TUM ABDELA &  
155 ALLEN AVE  
PORTLAND, ME 04103**CBL: 436 A024001**  
**Located at: 155 ALLEN AVE****Certified Mail 7010 1870 0002 8136 8398**

**Inspection Violations**

<b>Owner/Manager</b> TUM ABDELA &		<b>Inspector</b> Chuck Fagone	<b>Inspection Date</b> 6/15/2015
<b>Location</b> 155 ALLEN AVE	<b>CBL</b> 436 A024001	<b>Status</b> Passed	<b>Inspection Type</b> Complaint-Trash on Property/jun

# Framing Elevation

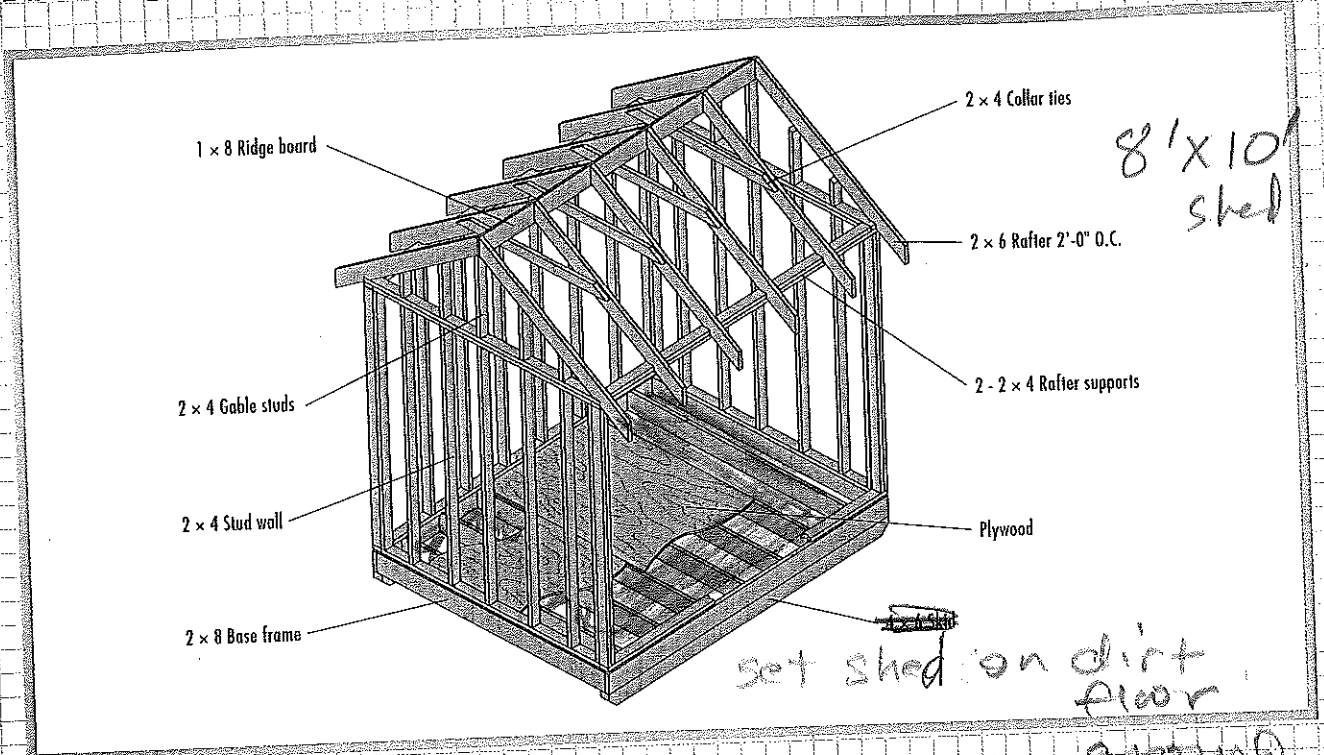
**Notes:**    *There is not a permit on file for the structure in the rear of the yard. The structure is not built to code and appears to be unsafe and will need to be removed.*
